The Do Nothing peak hour forecasts of significant **traffic flow** increases seem totally unrealistic based on personal experience of the M4 locally. Highways England (HE) agree that the M4 is already close to practical capacity which makes these forecasts even more puzzling. (para 3.1.1 et al of their response) Significant increases up to 2022 are surely even more unlikely when the M4 would be subject to 50 Km of road works, narrow lanes and traffic management. I would expect to see evidence of future peak hour spreading under these conditions rather than significant peak hour growth.

Project	SMART MOTORWAYS PROGRAMME
	M4 JUNCTIONS 3-12
Drawing title	ENVIRONMENTAL MASTERPLAN
	REGULATION 4(2)(e)
	SHEET 14 OF 61
	LOWER EARLEY

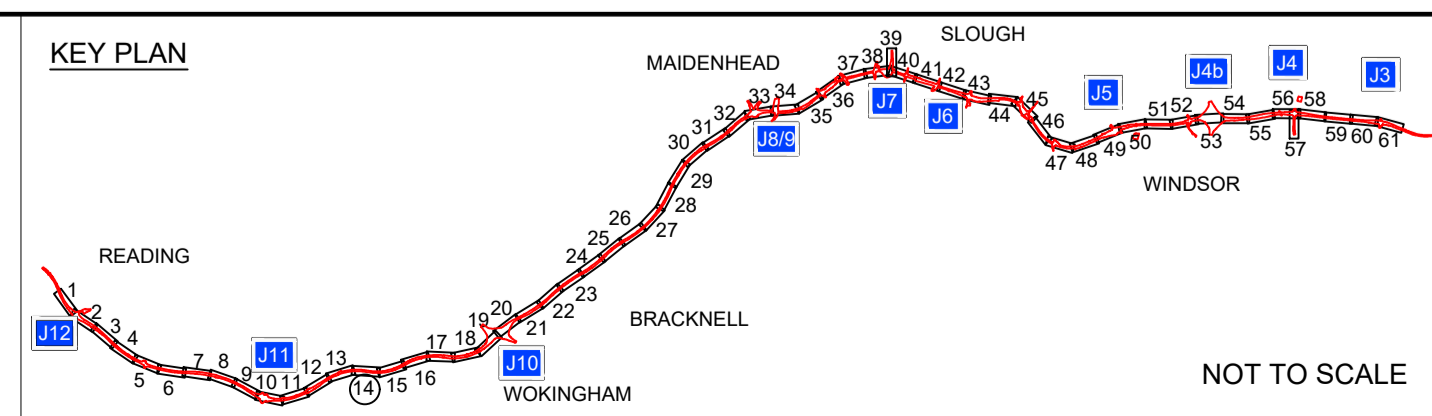
Most properties in Lower Earley are 30 years old and planning decisions were made in the late 1970s or early 80s presumably on the basis of M4 traffic forecast over the next 15 years to say the mid 90s. So for a further 20 years residents have endured massive, unpredicted increases in traffic and noise. However, the current approach projects traffic growth to 2022--yet another 7 years of potential traffic growth and unrestrained noise ----and then takes that as the base for assessing the impact of major traffic growth over a further 15 years. The conclusion is that the noise impact is neutral and no further mitigation is justified. Is this really fair and reasonable?

HE's eventual decision to provide low noise surfacing across **all** traffic lanes is, of course, welcomed. However, a barely perceptible reduction of only 3.5dB(A) will be practically meaningless to residents against the relentless scale and inherent variability of the noise source. In addition, the effectiveness of this surfacing has been shown by TRL to disappear completely with wear. Both points were covered in my submission and appear to be broadly accepted by HE despite the technical semantics involved. My comments are also supported by the standard DMRB advice manual, TRL research and general literature on traffic noise. In effect the measure will be seen by residents as far too little and definitely far too late!

The fact remains, and was observed during recent site visits, that local residents already suffer from what can be best described as totally unreasonable noise intrusion from the M4. The scheme, as proposed, will do little, if anything, to change this and even the status quo suggested by HE does not stand up to objective scrutiny. I remain of the view that a major, strategically important infrastructure scheme designed in Britain today, and costing around £0.8Bn, should be properly engineered to mitigate extensive traffic noise rather than merely attempting to accommodate future traffic demand.
